Date: 18 July 2023
Our ref: 437197
Your ref: EN020002

NSIP Reference Name / Code: National Grid: Bramford to Twinstead Reinforcement / EN020002

Title: Natural England's relevant representations in respect of National Grid's Bramford to Twinstead Reinforcement

ORIGINATOR DRAWING NO. AAA_BTT_Figure_1_AONB_Setting_Rev0

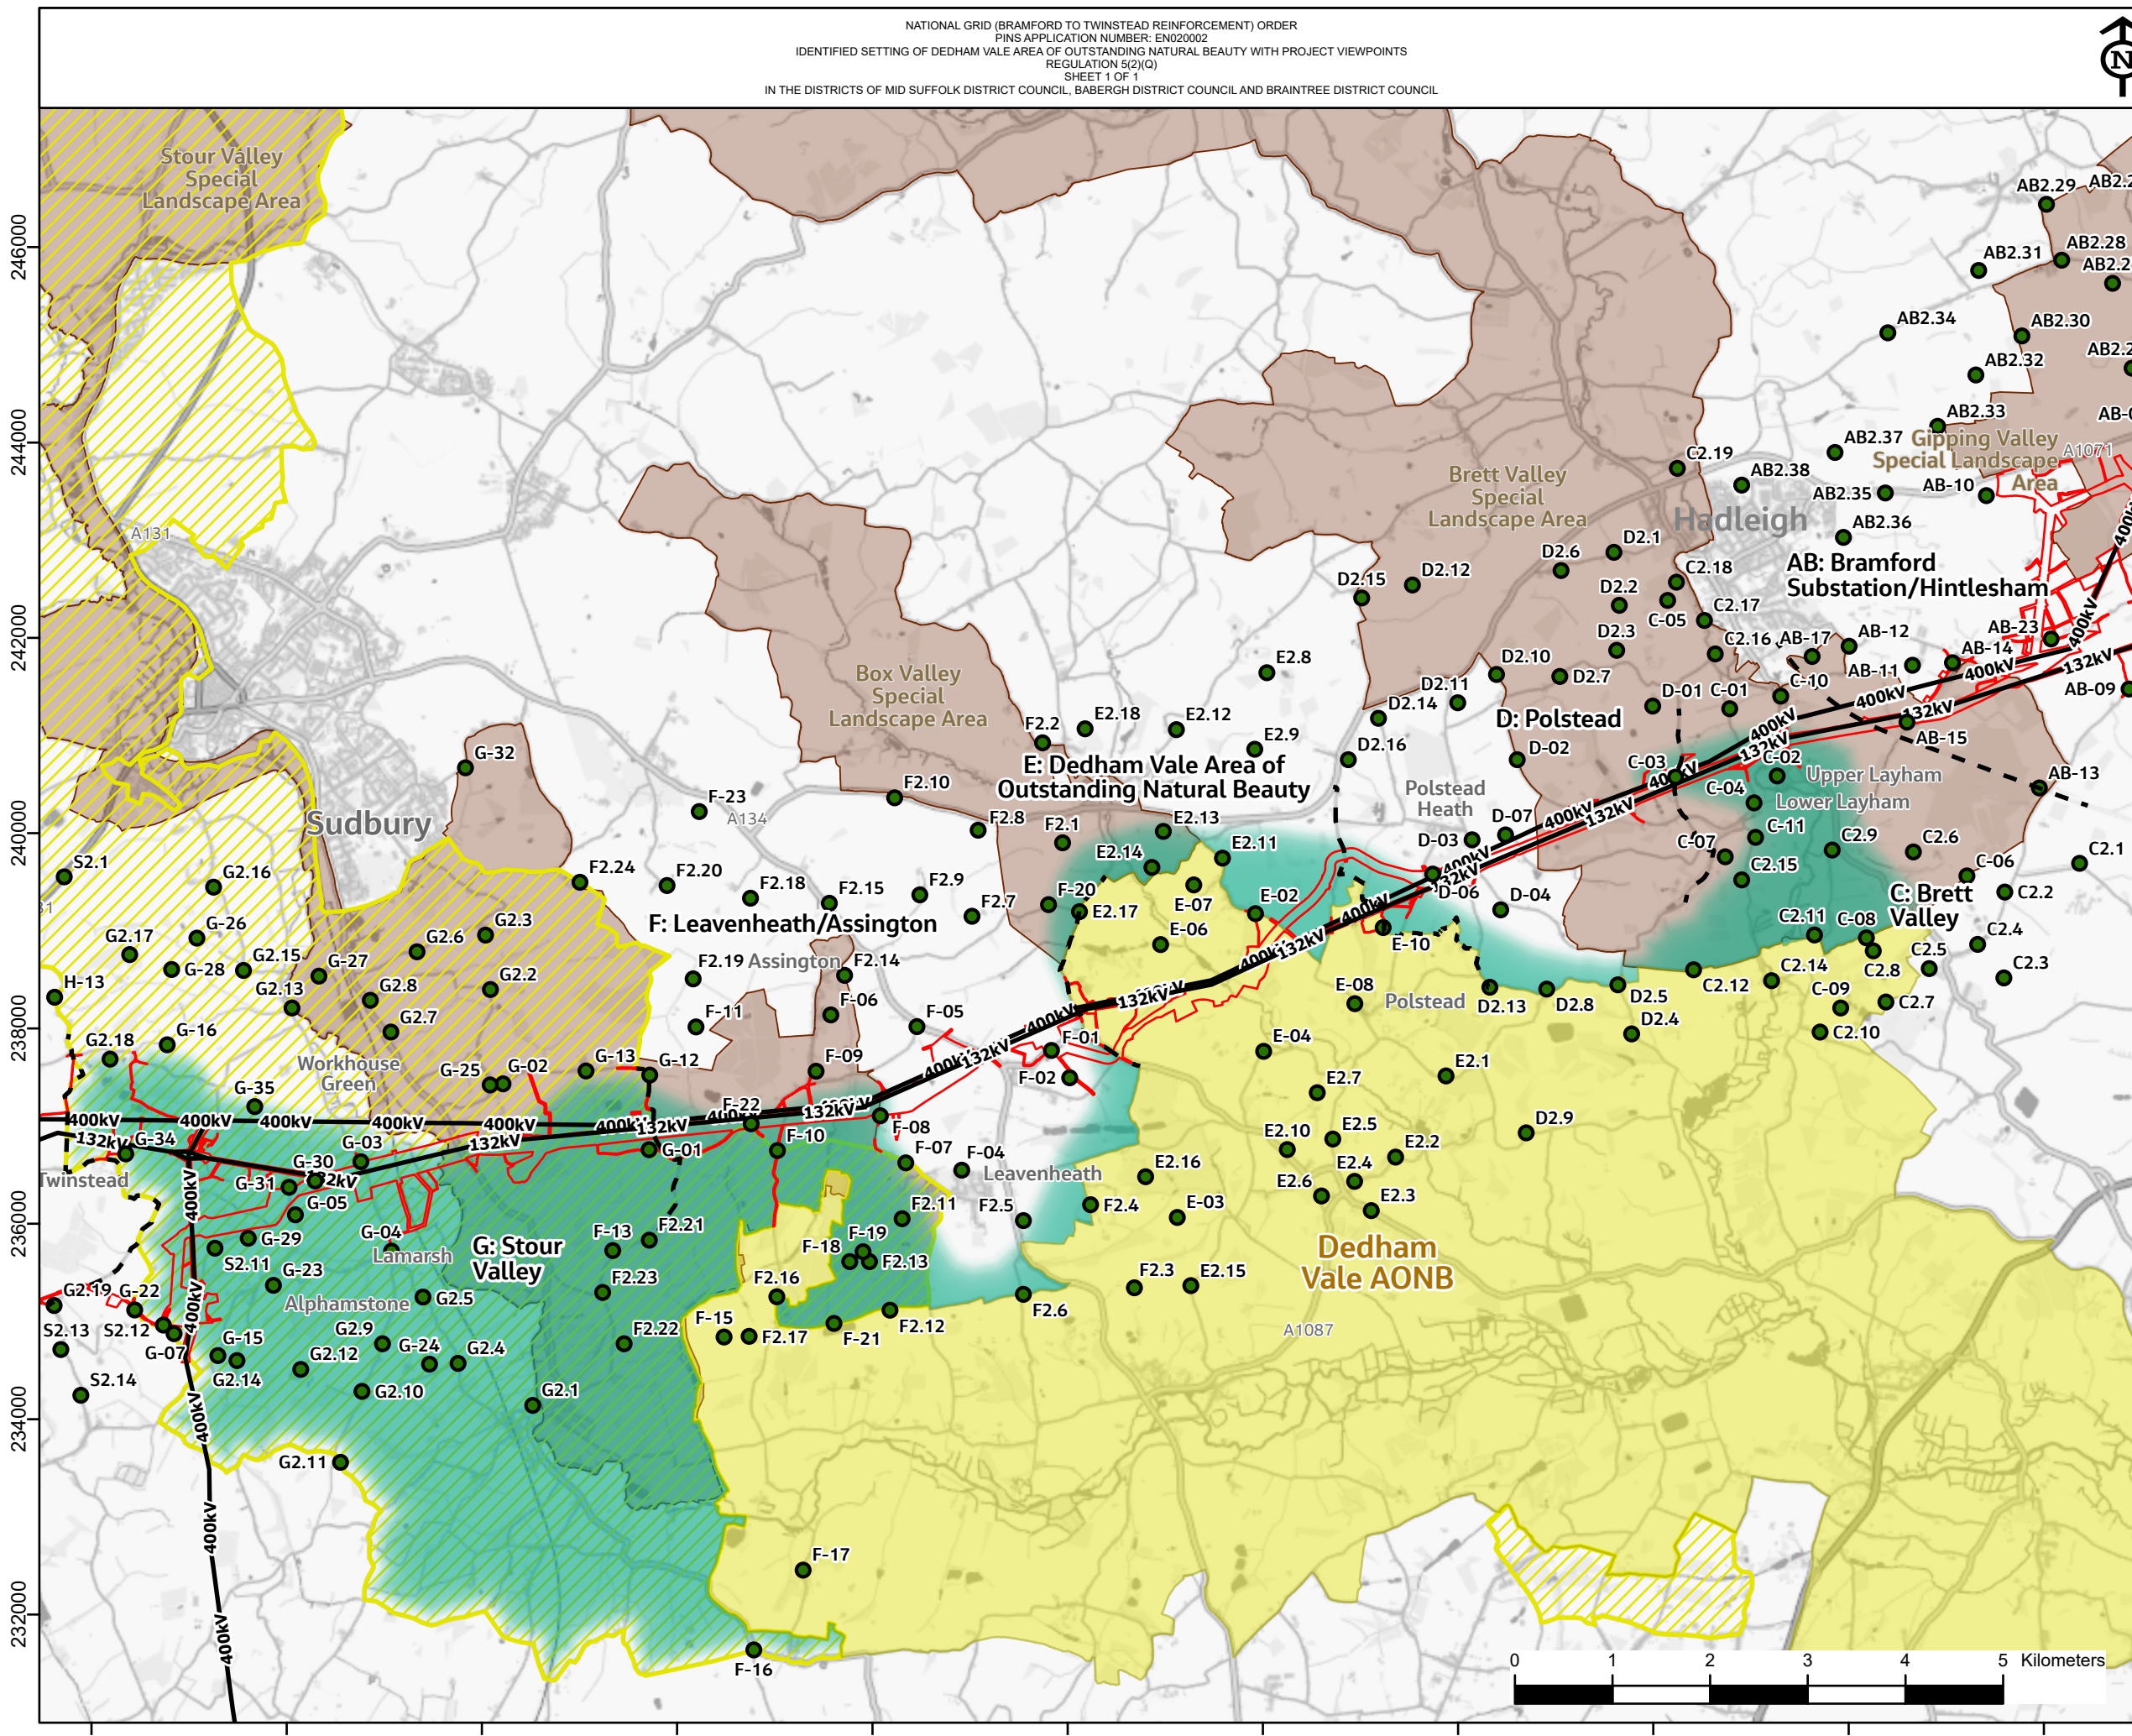
2.5.2.2 There are outstanding queries around 'the setting' of the AONB which the Applicant has not provided a response to. These queries were raised during a meeting held with the Applicant, Natural England and the AONB manager.

ORIGINATOR DRAWING NO.  
AAA\_BTT\_HabitatsFR\_Fig7\_1\_8\_Rev0

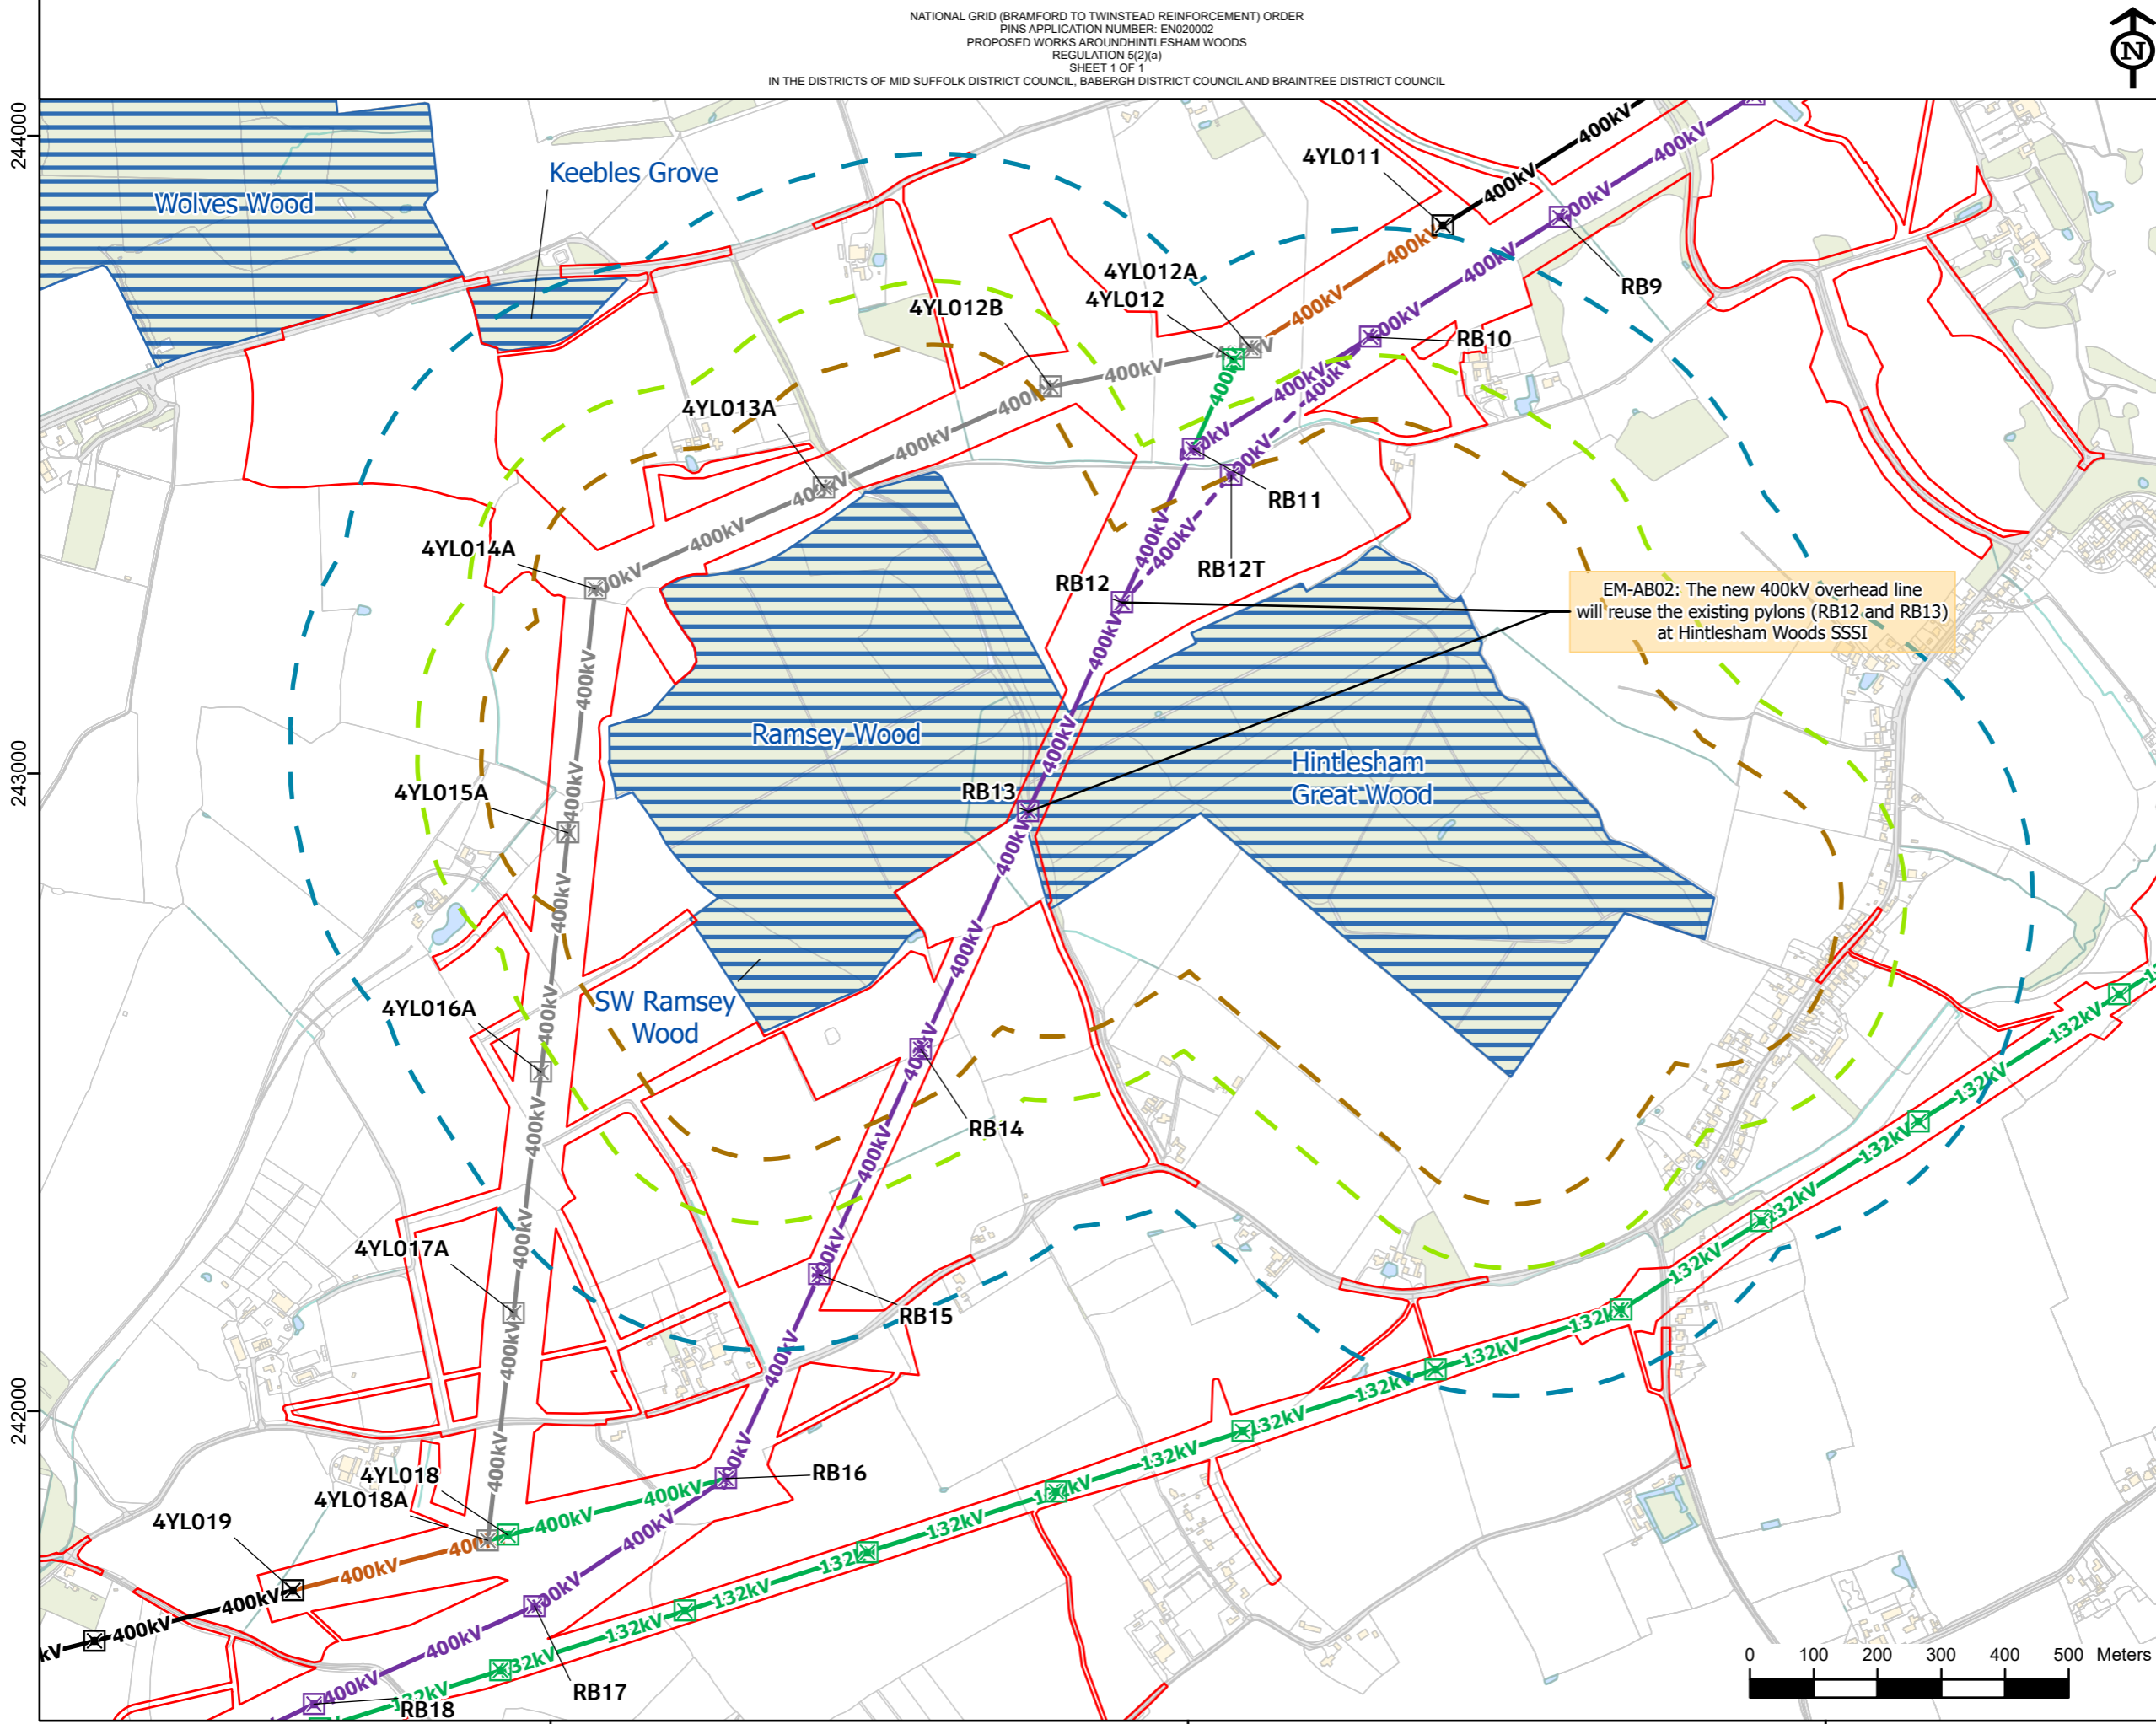
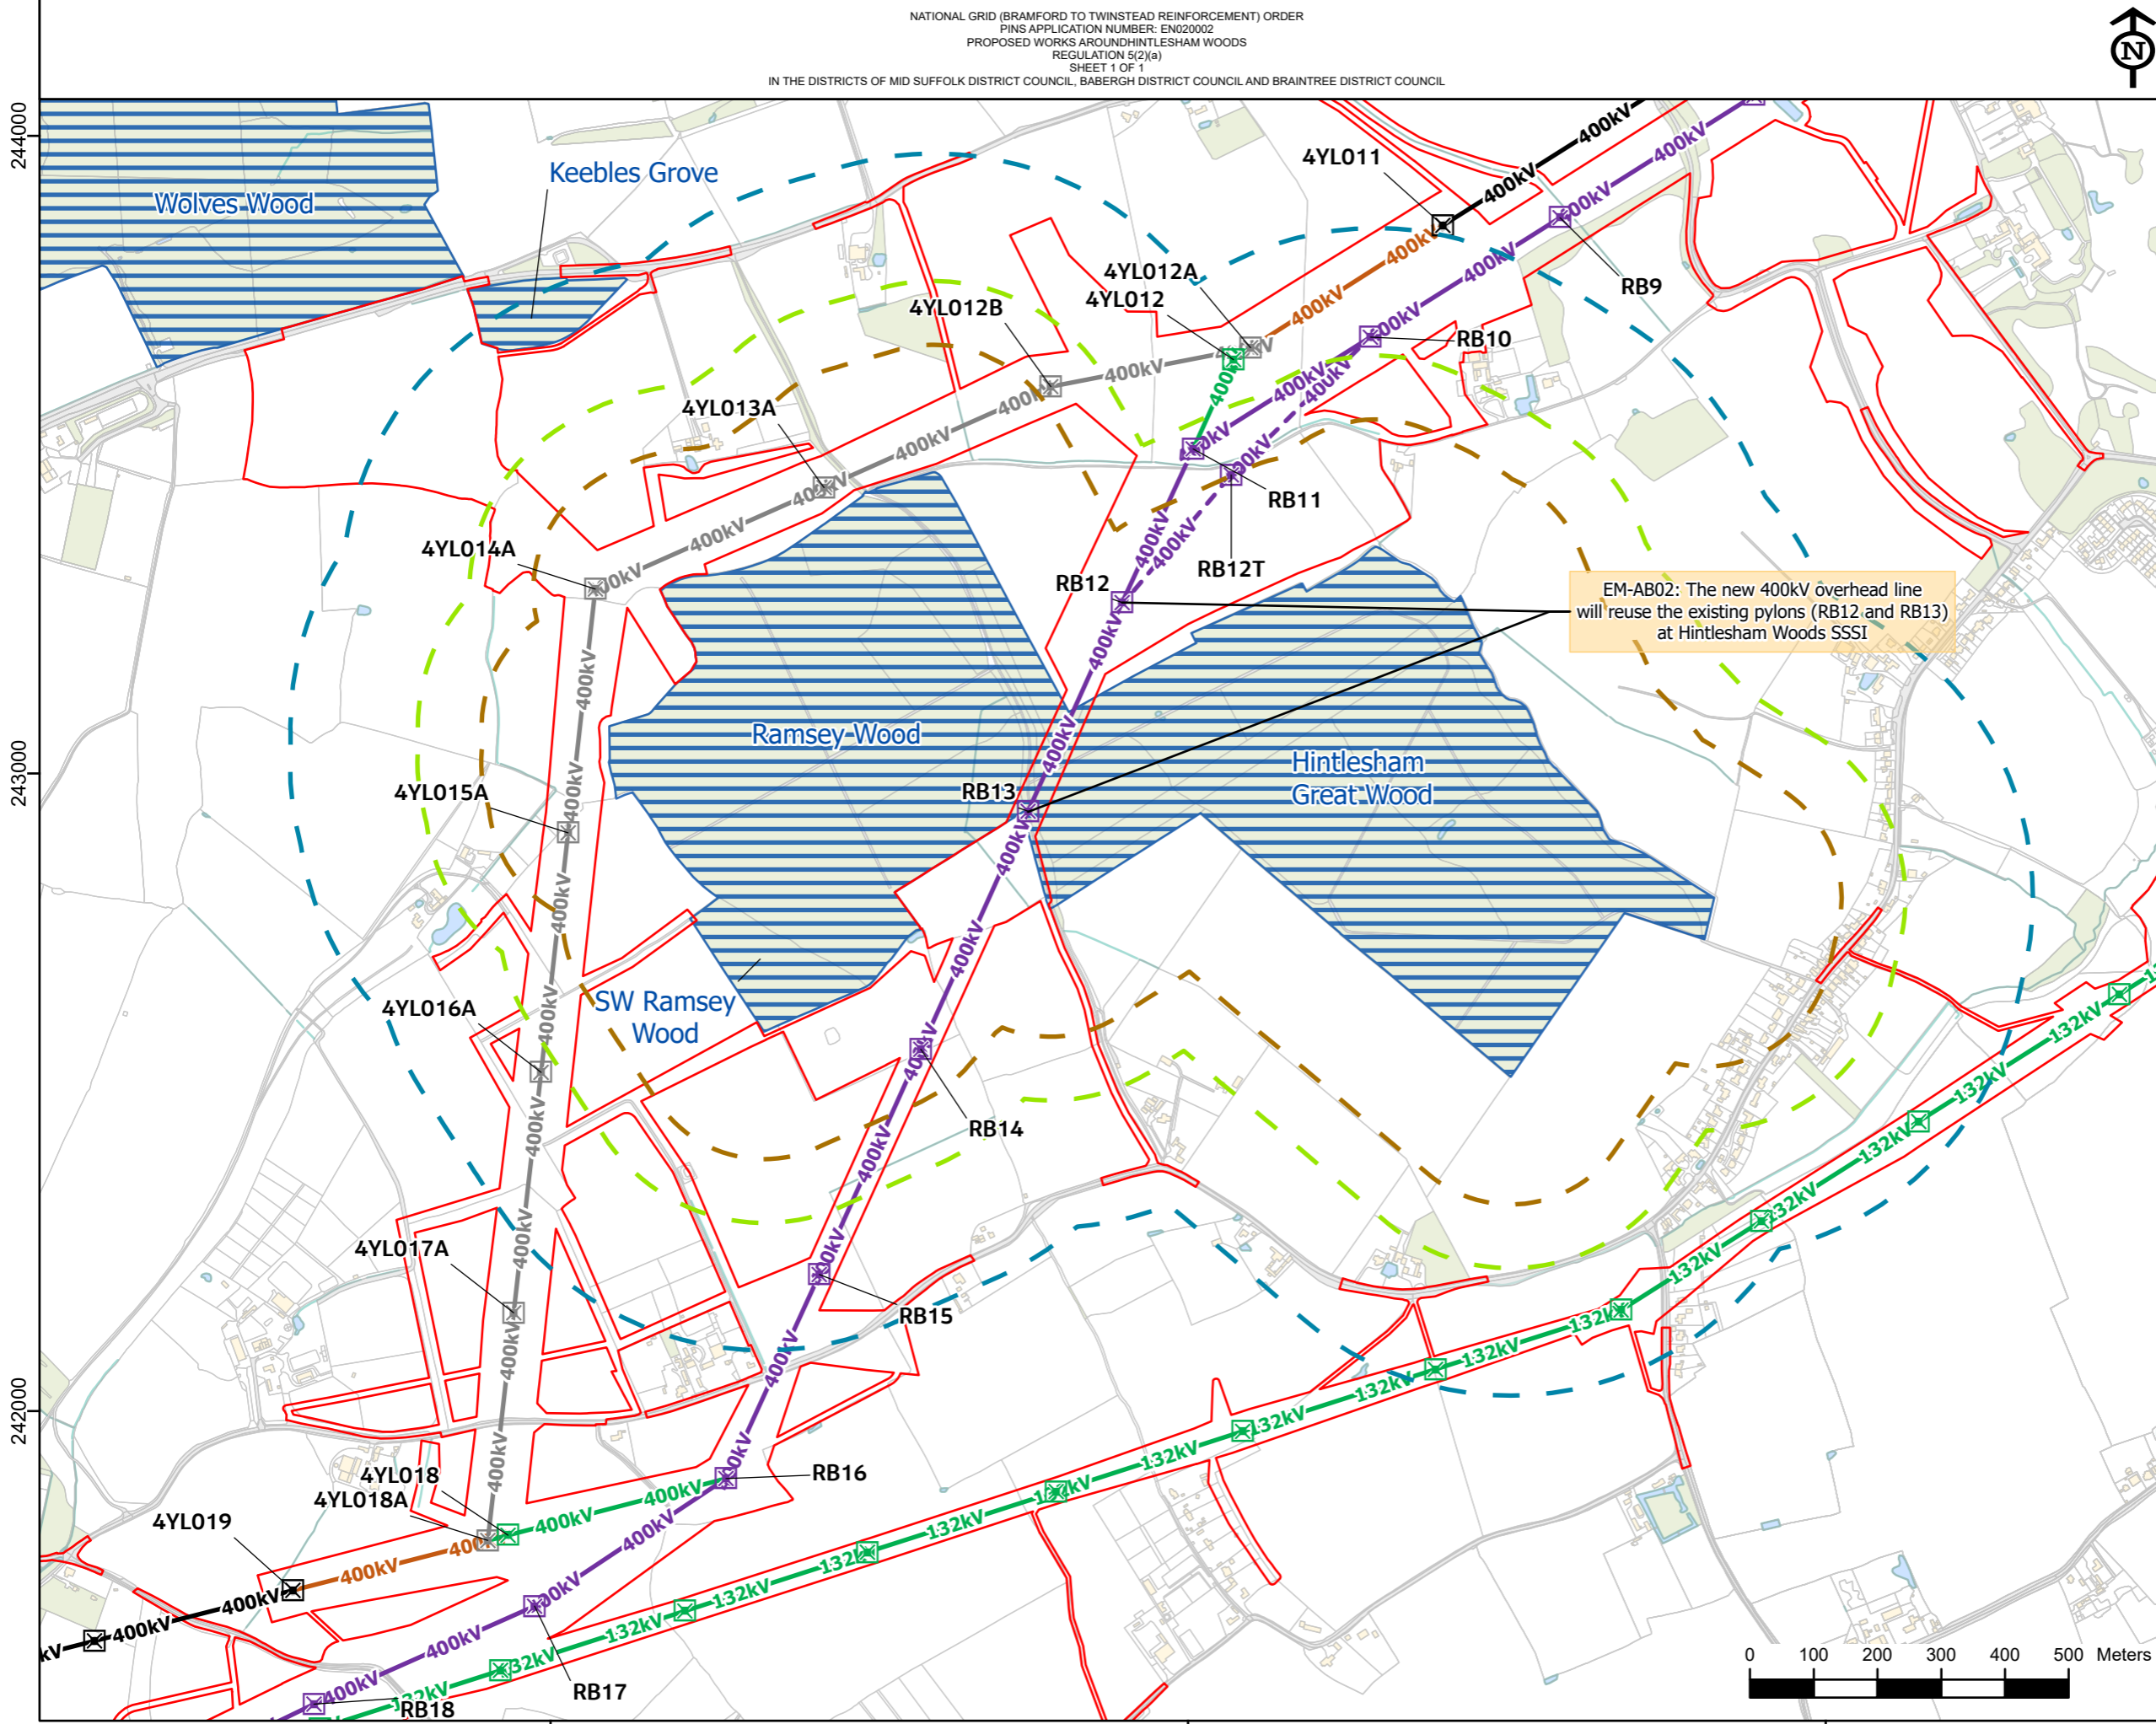
2.2.3.2 Potential impacts on the Hintlesham Woods SSSI 'assemblages of breeding birds - mixed: scrub and woodland' interest feature, during the construction phase. Natural England considers it a key issue that the noise assessment in ES Chapter 14: Noise and Vibration (application document 6.2.14) and the interpretation of this assessment in Document 6.3.7.1.2: ES Appendix 7.1 – Annex B Hintlesham Woods SSSI Assessment should be revised to include peak values as well as average sound power values. This is because sudden, unpredictable loud noises are more likely to startle birds and cause an escape flight response. Natural England is particularly concerned about the impact of construction noise on the nightingale population, which is part of the breeding bird assemblages interest feature. See Table 1 for Natural England's detailed advice on potential impacts on this interest feature.
